Subject: Chancel Cottage, Fir Lane Steeple Aston - 15/01328/LB and 15/01327/F

Thank you for passing these applications to me for comment. I previously dealt with applications 14/01552/F and 14/01601/LB which were refused due to their detrimental impact on the special interest of the listed building and character and appearance of the conservation area and setting of the neighbouring grade II* listed building.

Fig.29 - Proposed First Floor Plan

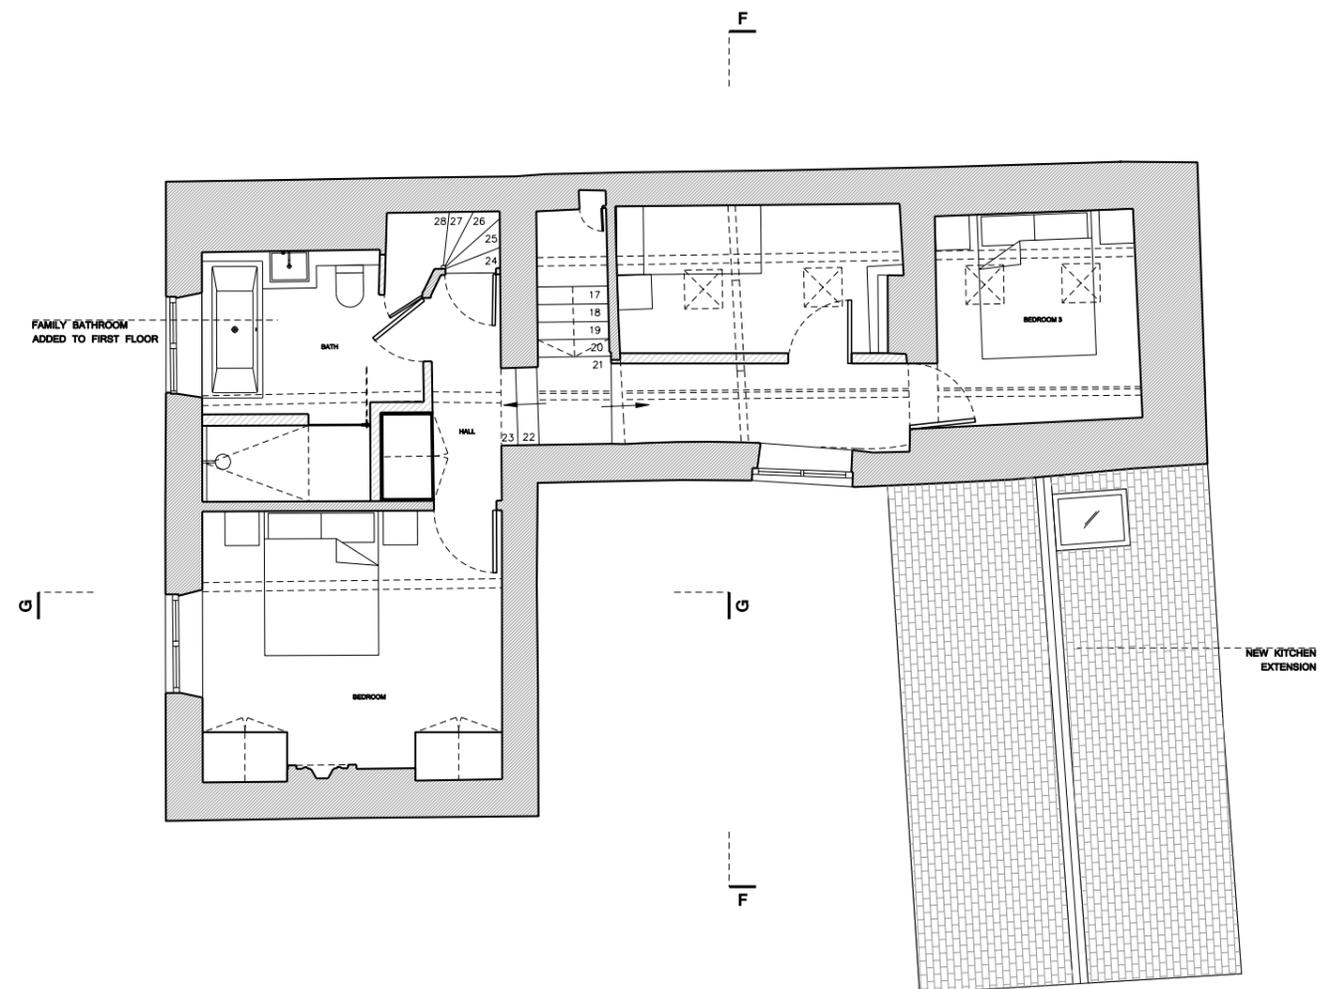
- The harm caused by the opening of a door at first floor level relates to the loss of fabric and the change in function by bringing a former outbuilding / stable into full domestic use. In an acceptable scheme the harm caused could potentially be outweighed by the public benefit of bringing this section of the building into use. This is not an acceptable scheme and therefore there is no public benefit to outweigh the harm.

Chancel Cottage - Proposed West Elevation

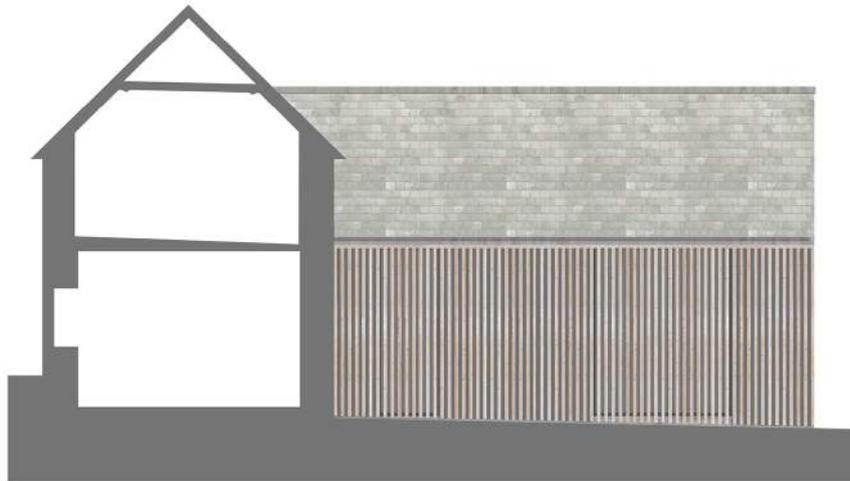
- The change in material from timber to stone on the proposed kitchen extension is considered to be positive, but the form, scale and massing are still considered to be detrimental to significance of the listed building. The proposal to create an 'additive' nature to the extension is not considered to address this. It is unclear how this alteration to the form is considered to be *'characteristic of how the house (and many other historic houses) has evolved, changing to meet the needs of its occupants and represents the physical evidence of its history'*. The proposed extension is in a modern rather than traditional form and is intended to be built in one construction phase and is not an evolving traditionally constructed building.
